DECISION DELEGATED TO HEAD OF PLANNING

Application No:	H11-0515-23	Applicant:	Ms K Streets
Proposal:	Erection of outbuilding - Retrospective		
Location:	Holmhurst 24 Wisbech Road Long Sutton		
Terminal Date:	9th August 2023

Rebuilt Outbuilding Design Details

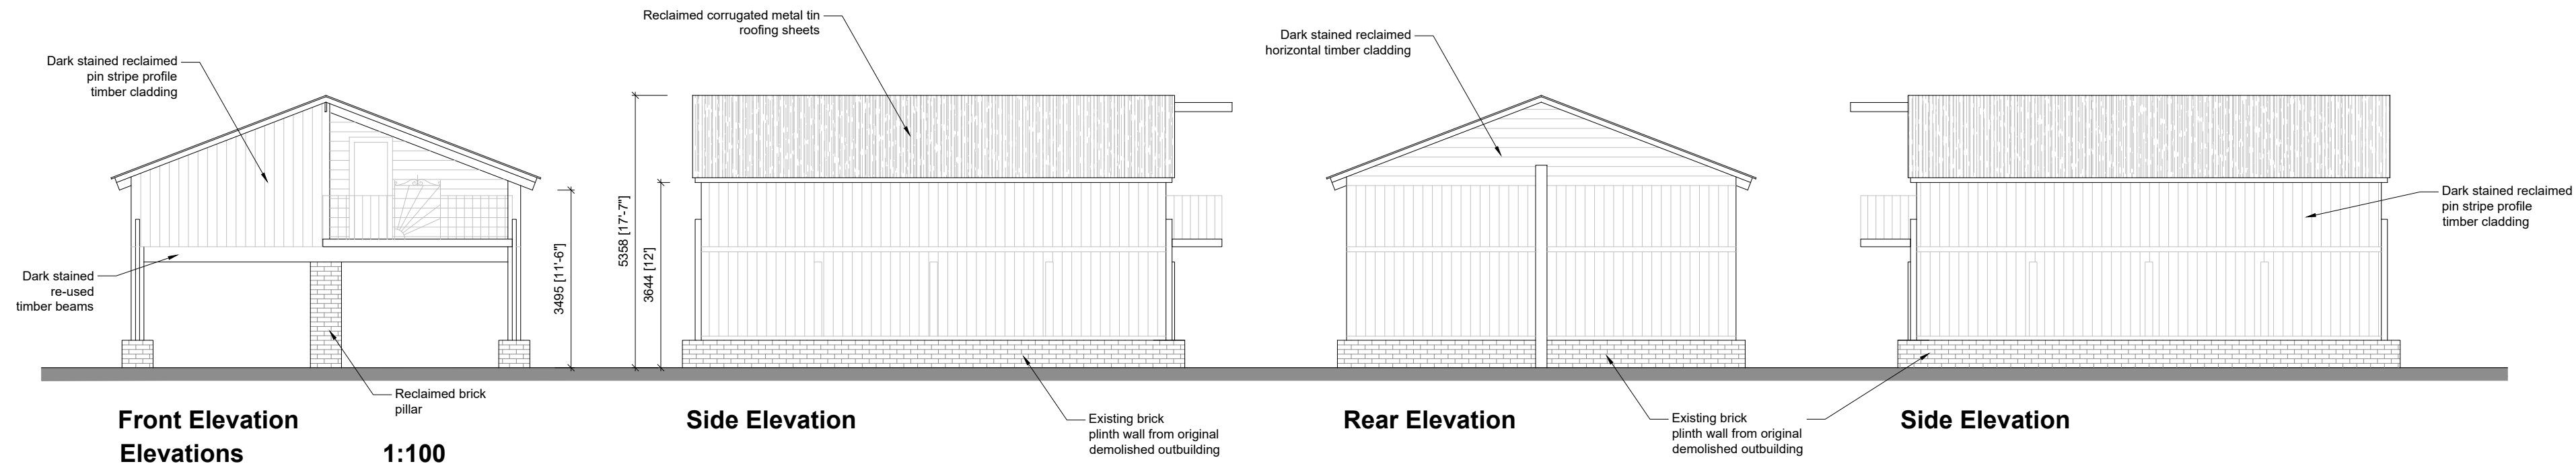
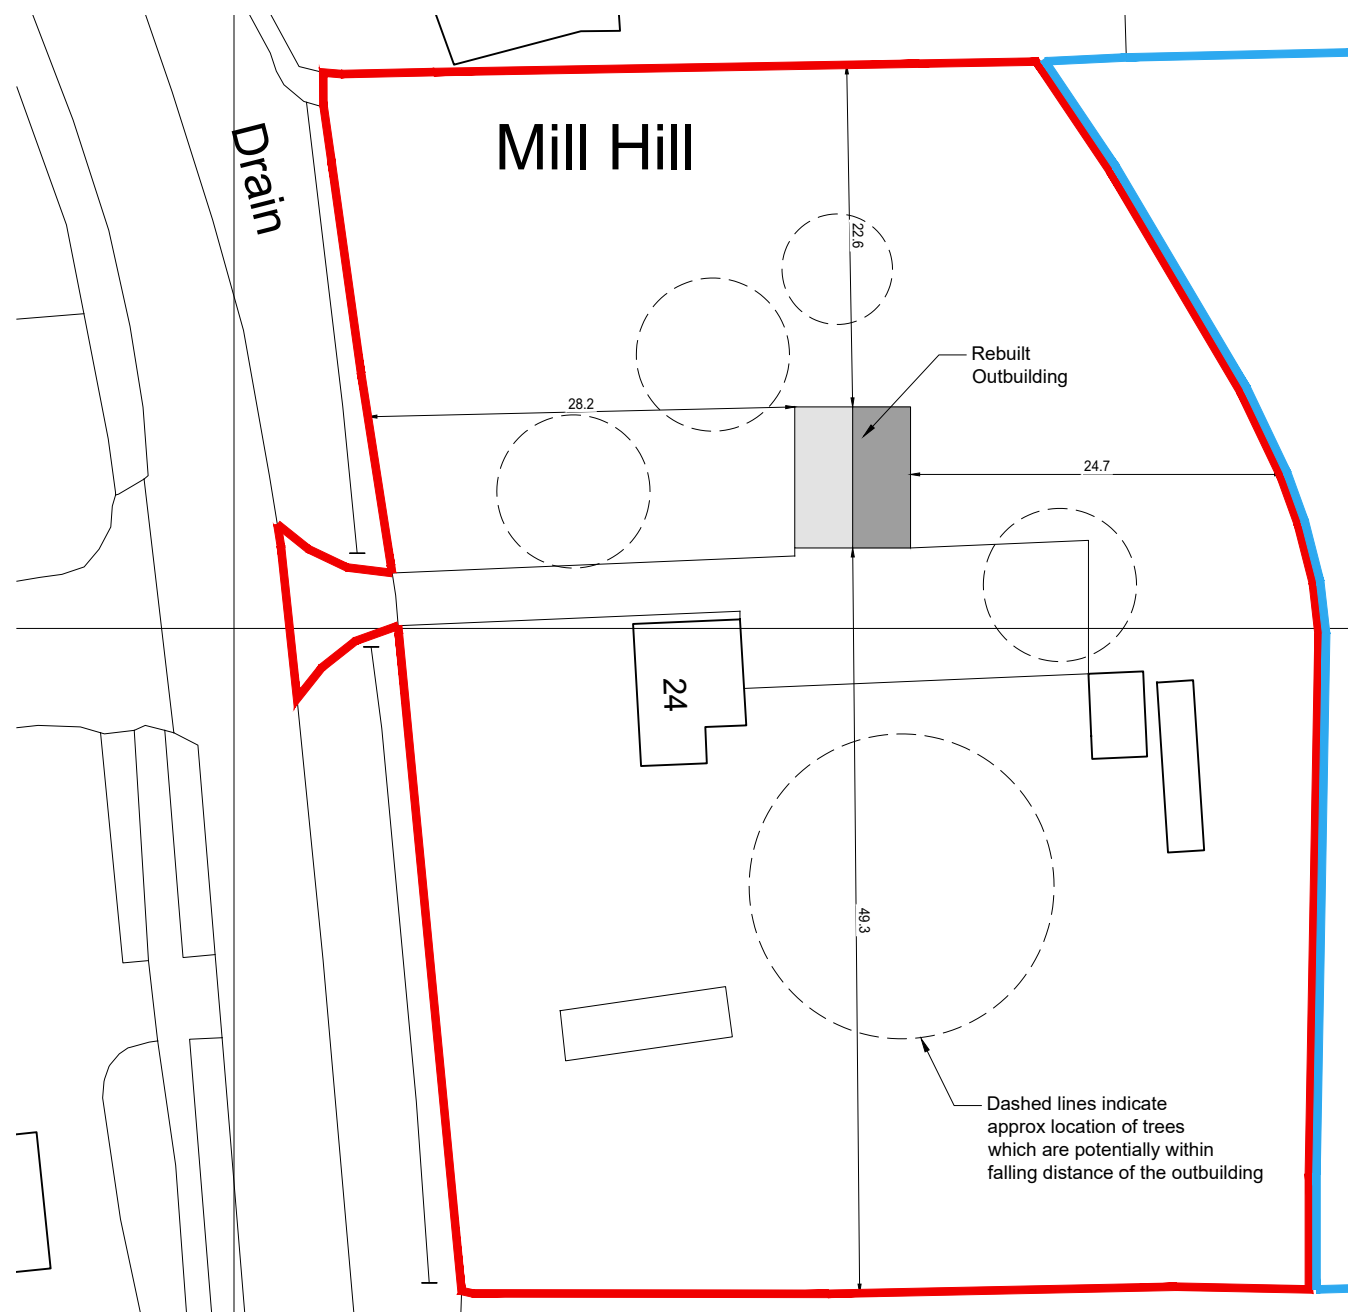
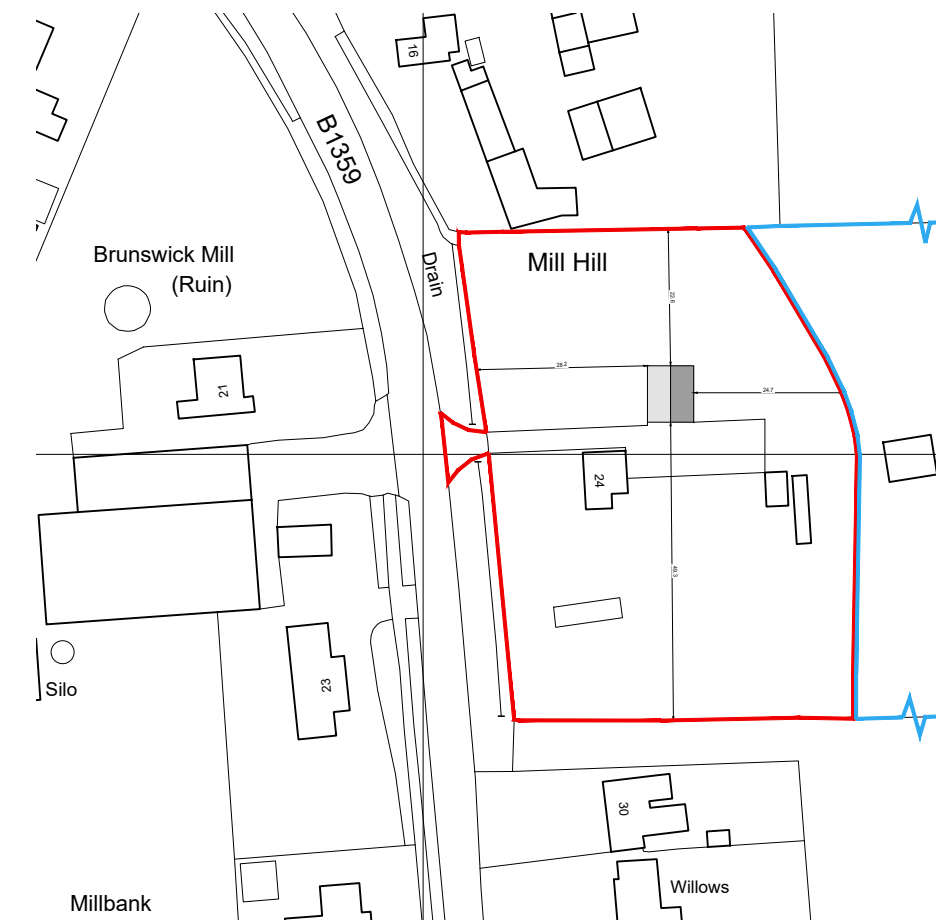
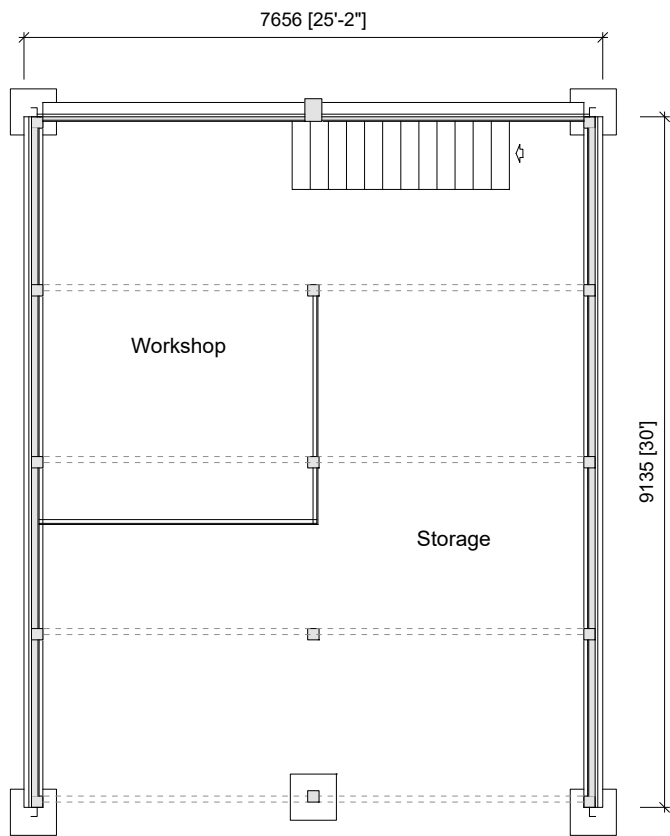
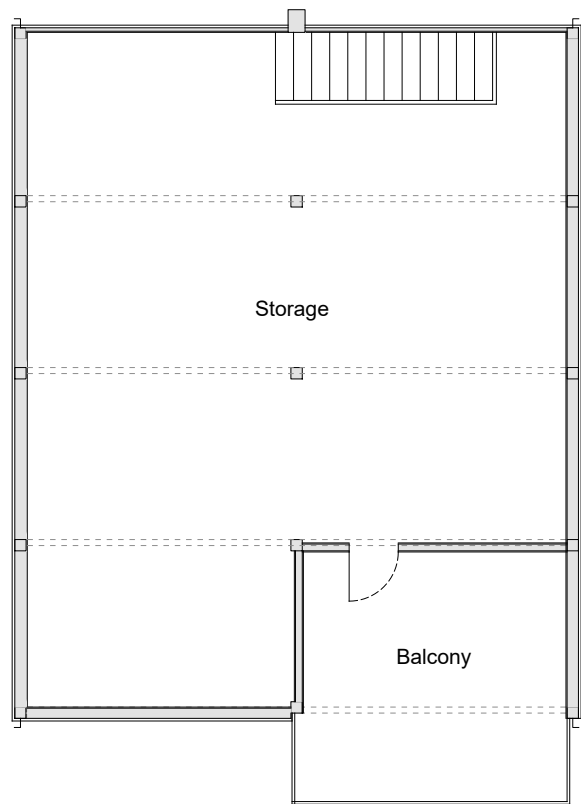
The proposed outbuilding is 2 storey structure, measuring 9.135m x 7.656m (footprint) with a dual pitch roof and a frontage balcony. The height at eaves is 3.495m, and the height of the roof apex is 5.358m.

In this instance, the erected structure which this proposal seeks retrospective consent for is a 2 storey chalet style barn/shed type building. The structure is situated ~3m from the listed building (at the closest points) and as a 2 storey structure is readily visible from the roadside and features very prominently within views of the heritage asset.

It is the opinion of the Local Planning Authority that the structure is an unattractive and incongruous addition to the curtilage of the listed building. The applicant has stressed that they have sought to rebuild an outbuilding that was on the site previously, and states that a former officer of the LPA advised them that a like-for-like rebuild would not need consent. However, neither the agent nor the applicant have been able to produce evidence of this advice and no such advice is catalogued within the LPA's records. Additionally the local planning authority has been able to obtain photographic evidence of the former building, inspection of which and comparison against the Officer's Site Photos reveals that the structure which has been erected in its place (subject to this consent application) is far larger in size and scale to that which it replaced, and that the former structure was extremely dissimilar in architectural style, with the replacement building appearing far more like a chalet, with a balcony and brick plinths, compared to the former structure which appeared to be a simple, single storey timber shed-type structure.

The newly erected building is far larger in scale than that which it replaces and is of a totally different style, considered inappropriate for a setting within such close proximity to a locally prominent listed building. The visual impact that the proposed structure bears upon the host listed property and the close proximity it is set within, relatively compared to its scale results in highly infringed views of the listed property, particularly from the roadside and wider public realm. Therefore, it appears totally incongruous in the setting of its host, having an unacceptable impact upon the setting of the listed building, failing to either preserve or better reveal its significance and also to respect the wider historic environment in terms of scale, massing, and visual impact upon a locally prominent heritage asset. Therefore, the proposal is considered to be in breach of Policies 2, 3 and 29 of the SELLP.

For the reasons listed above, this application is deemed breach Policies 2, 3, and 29 of the SELLP and therefore, the recommendation is to refuse permission.
